Application No: LU/145/21/PL
Site Address: 12 Cornwall Road Littlehampton BN17 6EE
Description of works: Change of use from (C3) Dwelling house to 9 bed House in Multiple Occupation (Sui Generis)

Thank you for your internet representation made on 20th May 2021 which has been recorded as an objection with the comments as follows:

Proposed Site Plan
Scale 1:50

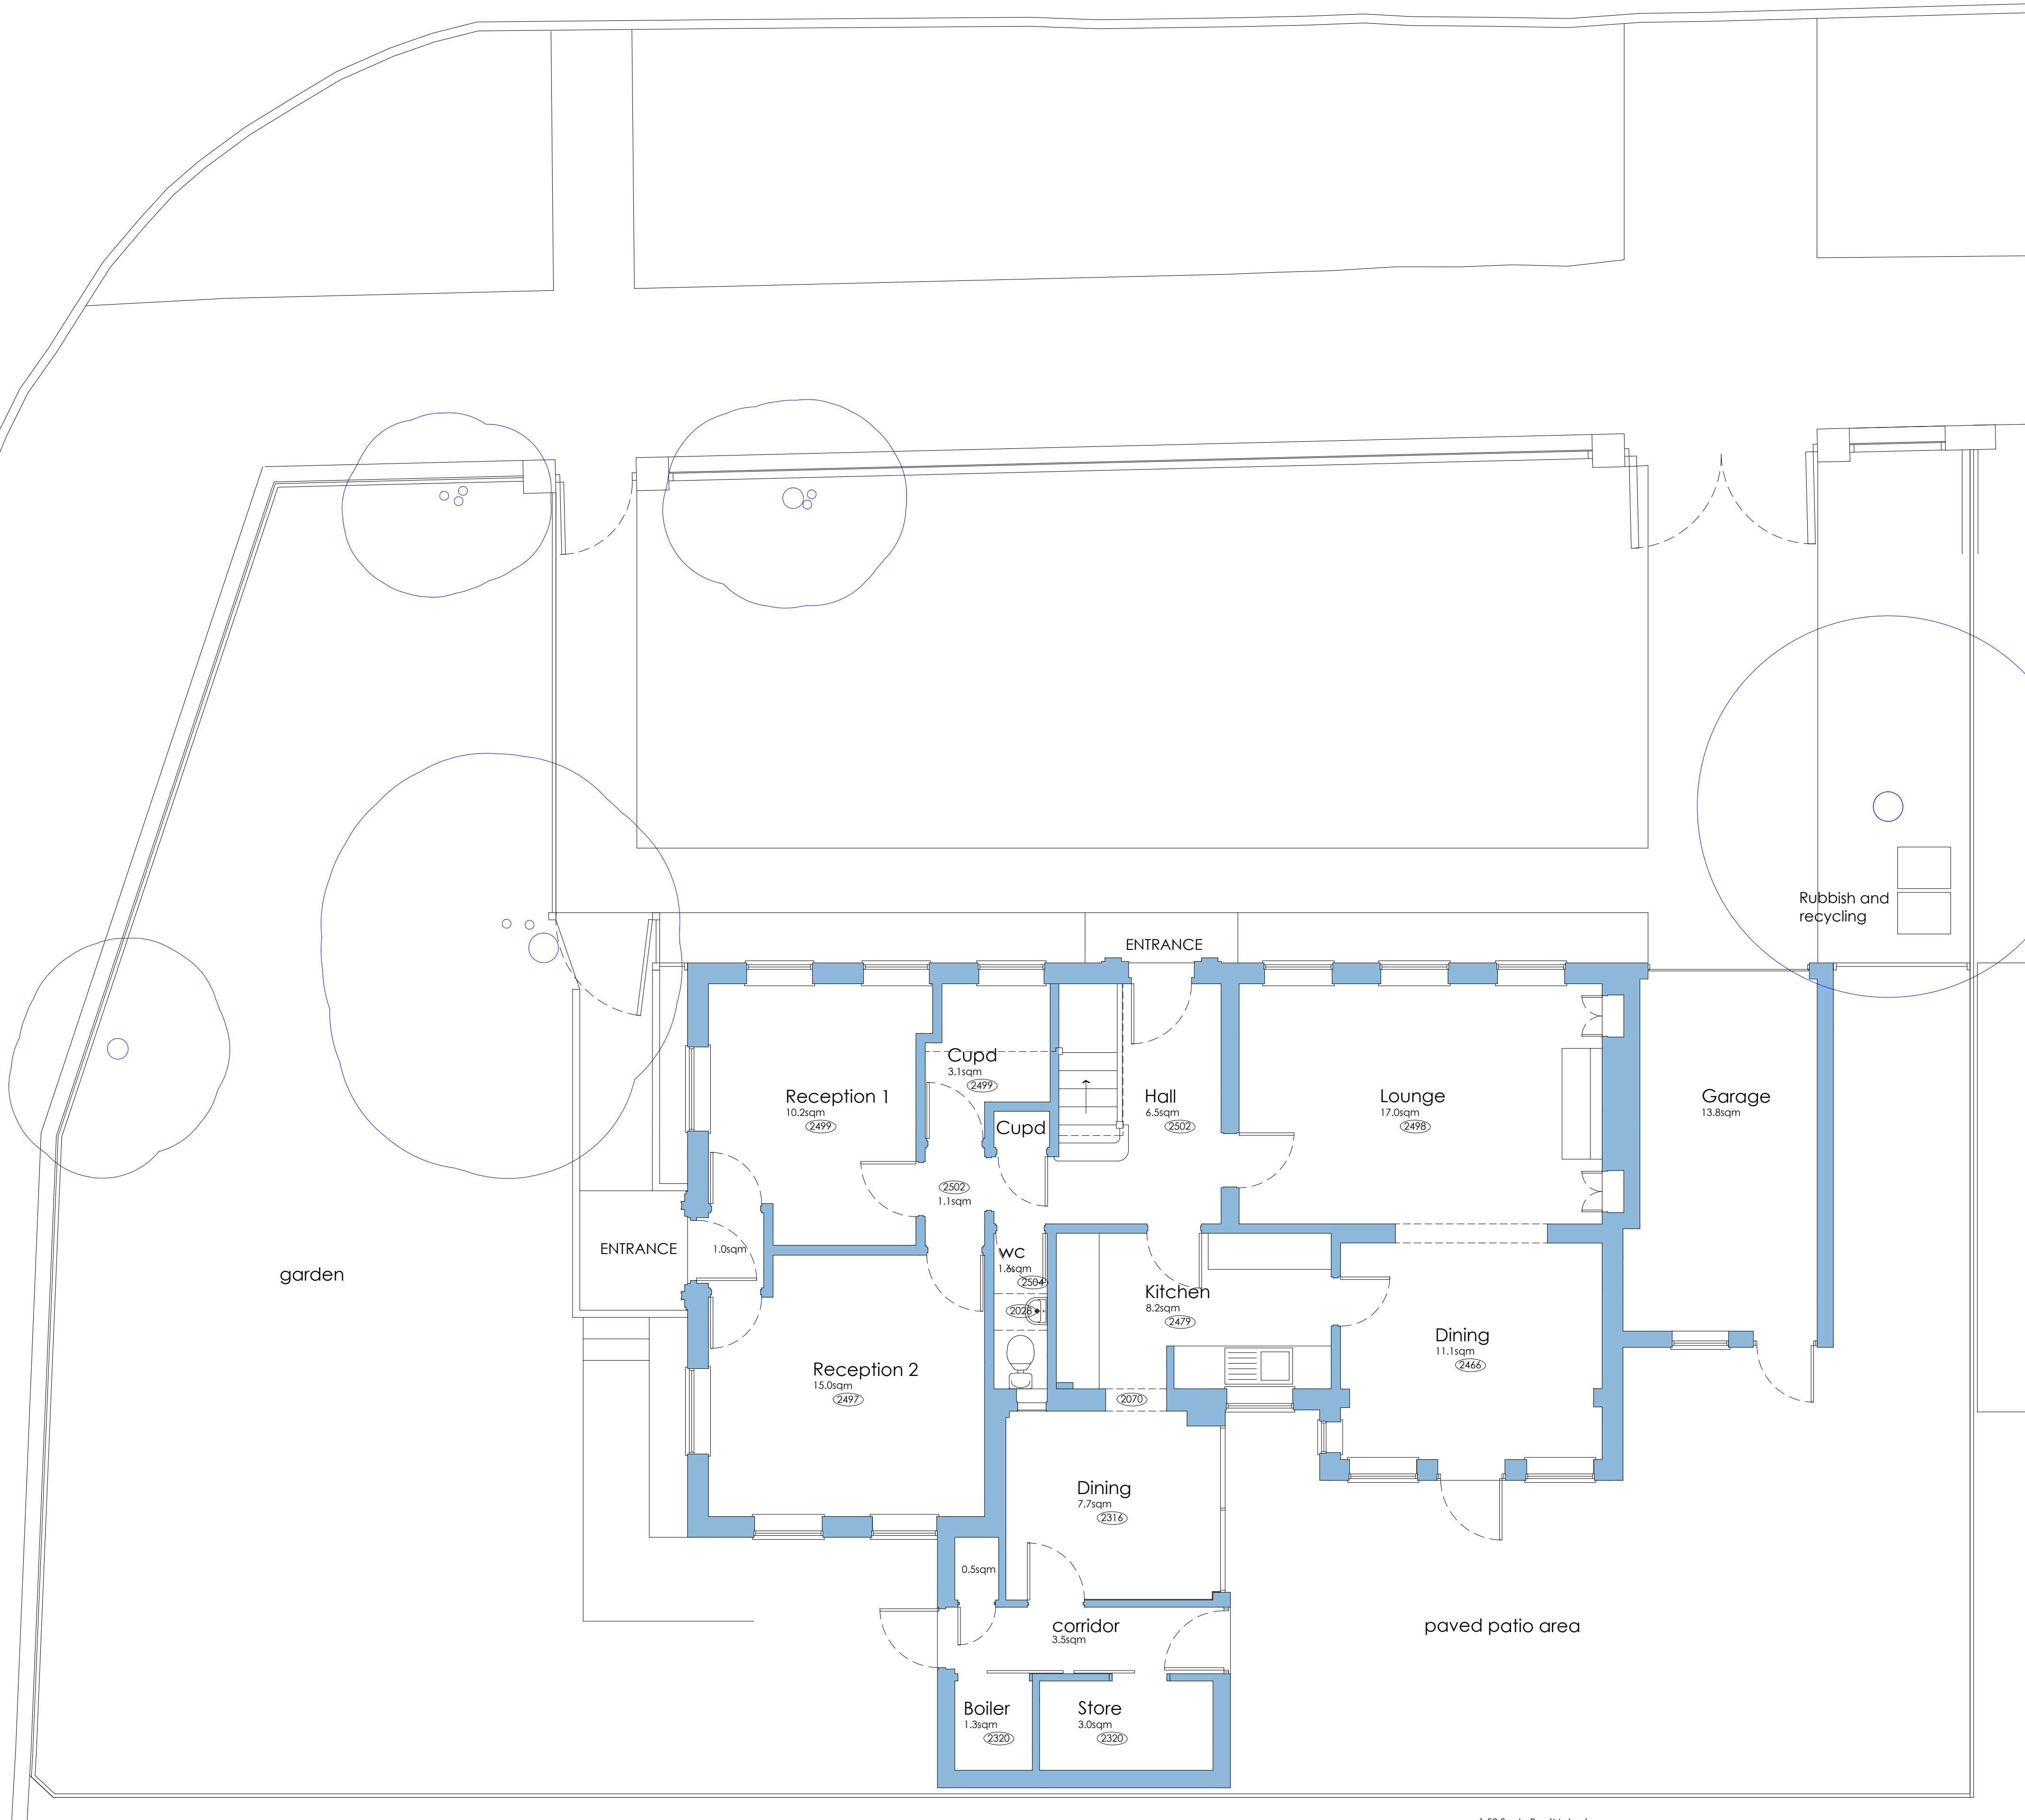
Although I support the desire for more affordable housing in the area, I object to this development unless suitable arrangements are made for the impact of increased vehicle parking. I note that space has been allowed in the plans for 2 cars and 8 bicycles. I think it is naive to consider that only 2 cars would be applicable to the residents of 9 rooms. Cornwall Road is already completely jammed up with vehicular parking around the site of this plot. Cars are often parked on verges or illegally protruding out of the end of Blakehurst Way directly opposite the plot. Parked cars and vans also extend down Blakehurst Way back to Whiteways Close and, most dangerously, right up to the junction of Cornwall Road with Arundel Road. Because of the issue of parked cars on both sides of Cornwall Road, cars turning in from Arundel Road often have to wait on the junction for other vehicles to come along Cornwall Road to exit onto Arundel Road. I strongly advise that those who are to consider this planning application go out in person to view the state of the parking around the plot. It is already dangerous and any addition parked vehicles would make it treacherous.
